Boston Alternative Energy Facility – Environmental Statement

Chapter 7 Consultation

Client: Alternative Use Boston Projects Ltd
Planning Inspectorate Reference: EN010095
Document Reference: 6.2.7
Pursuant to: APFP Regulation: 5(2)(a)
Reference: PB6934-RHD-01-ZZ-RP-N-3007
Status: 0.0/Final
Date: 23 March 2021

Project
BOSTON ALTERNATIVE ENERGY FACILITY - ES
LANDSCAPE & VISUAL IMPACT ASSESSMENT
Drawing Title
PHOTOMONTAGE 01
VIEW 3 FROM FISHTOFT
Date: NOVEMBER 2021 9.15 (sheet 2 of 5)

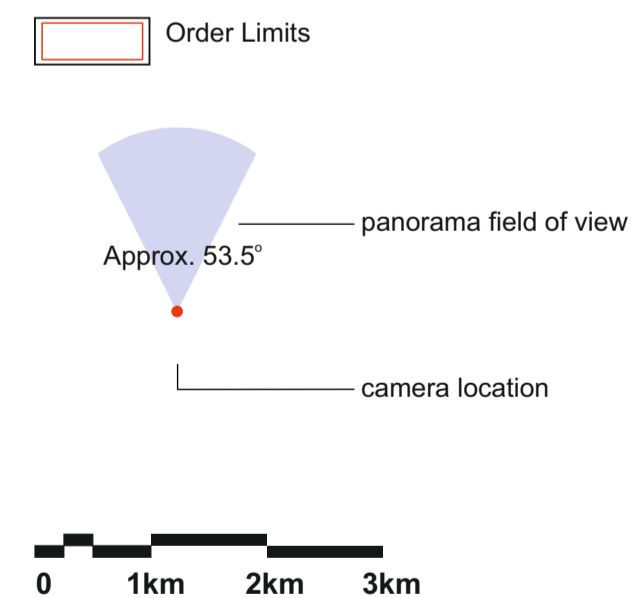
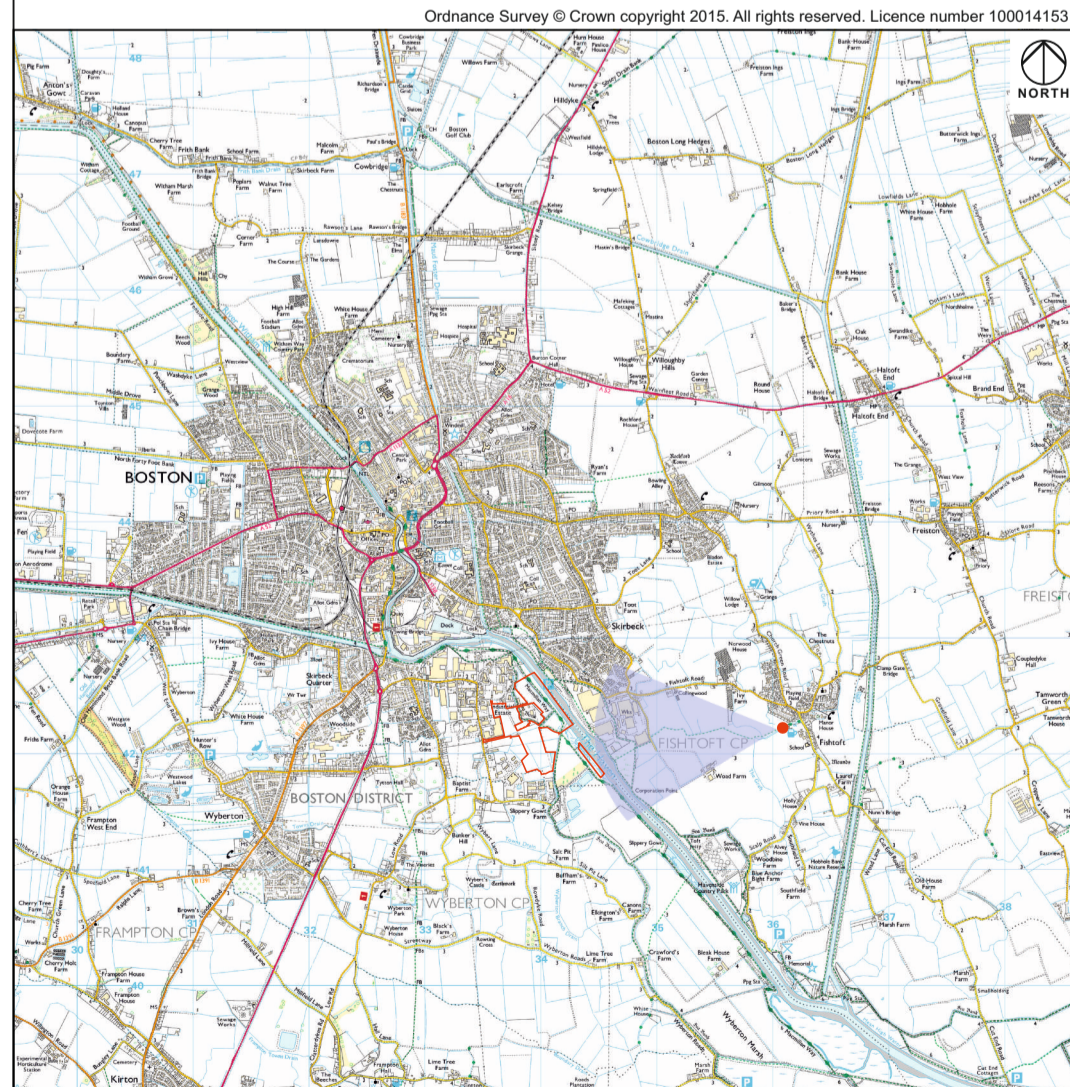
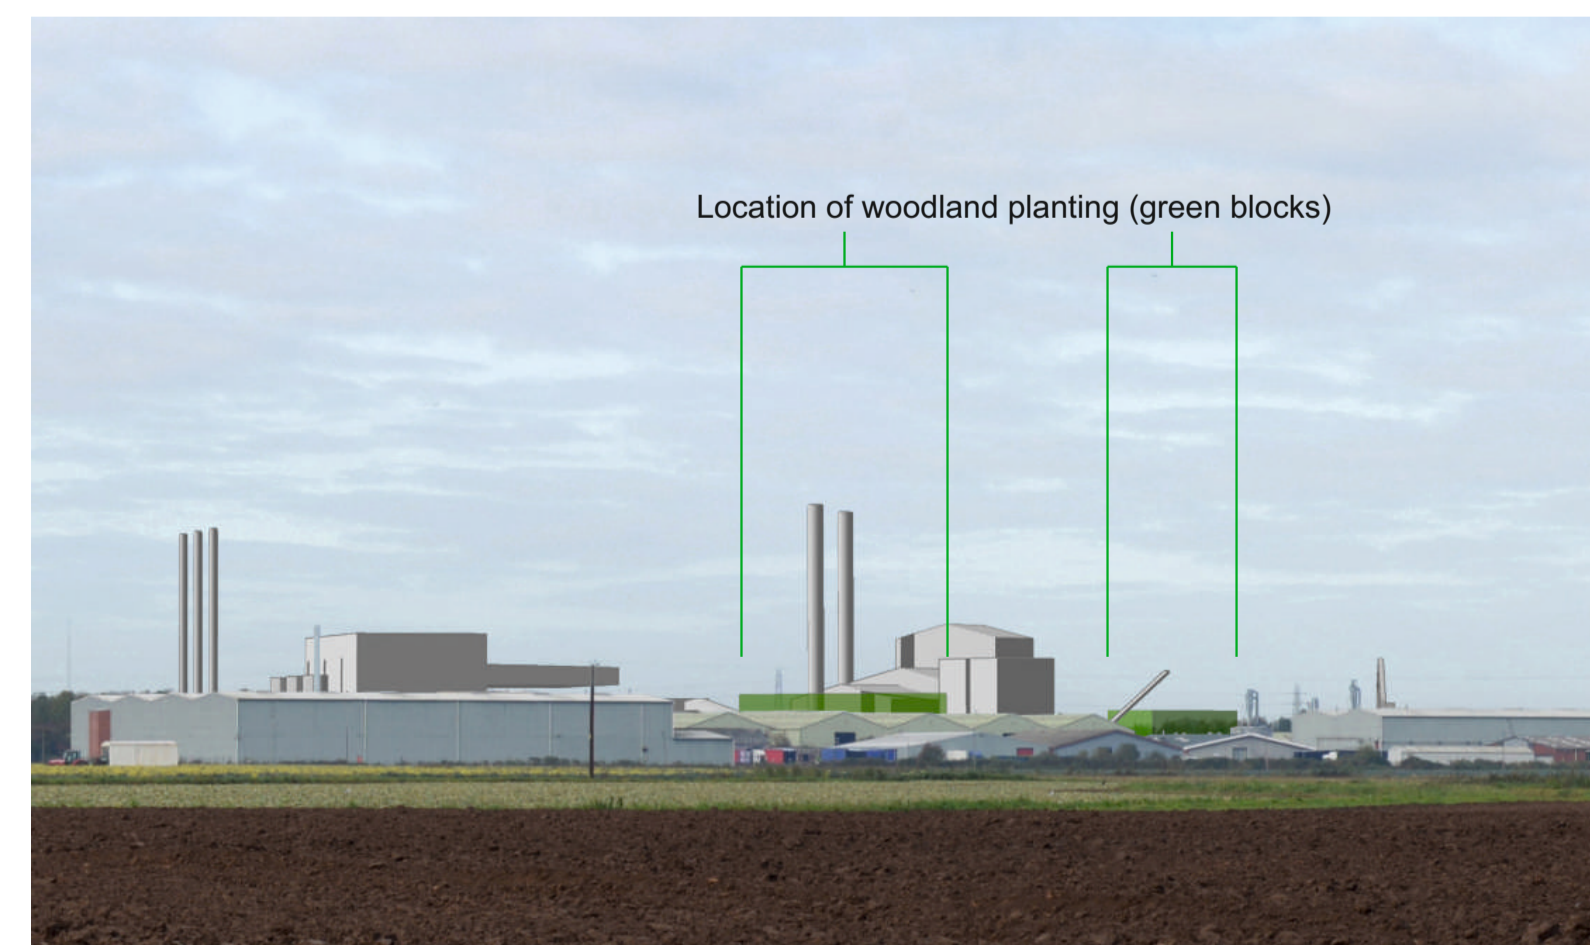
<p>Concerns about the ability of the company to deliver the project.</p>	<p>Noted, see the Funding Statement (document reference 3.2) provided with this application.</p>
	<p>Concerns about the impact of inclement weather in the Wash impacting on viability of BAEF to operate to full capacity.</p>	<p>Noted. Chapter 18 Navigational Issues; and Chapter 24 Major Accidents and Risk Management.</p>
	<p>What vermin control has been considered for the site when operational.</p>	<p>Refer to Chapter 23 Waste.</p>
	<p>We are unable to fully assess the project against the policies of the adopted Local Plan as there are no plans of the proposed structures to view and assess only simple written descriptions. At this stage in the consultation process, we are disappointed we cannot provide more clarity and would like to delay the next stage of the process until such time as detailed plans are available for more detailed assessment.</p>	<p>Addressed in Chapter 9 Landscape and Visual Assessment, Figures 9.15 – 9.20 show photomontages of the Facility.</p>
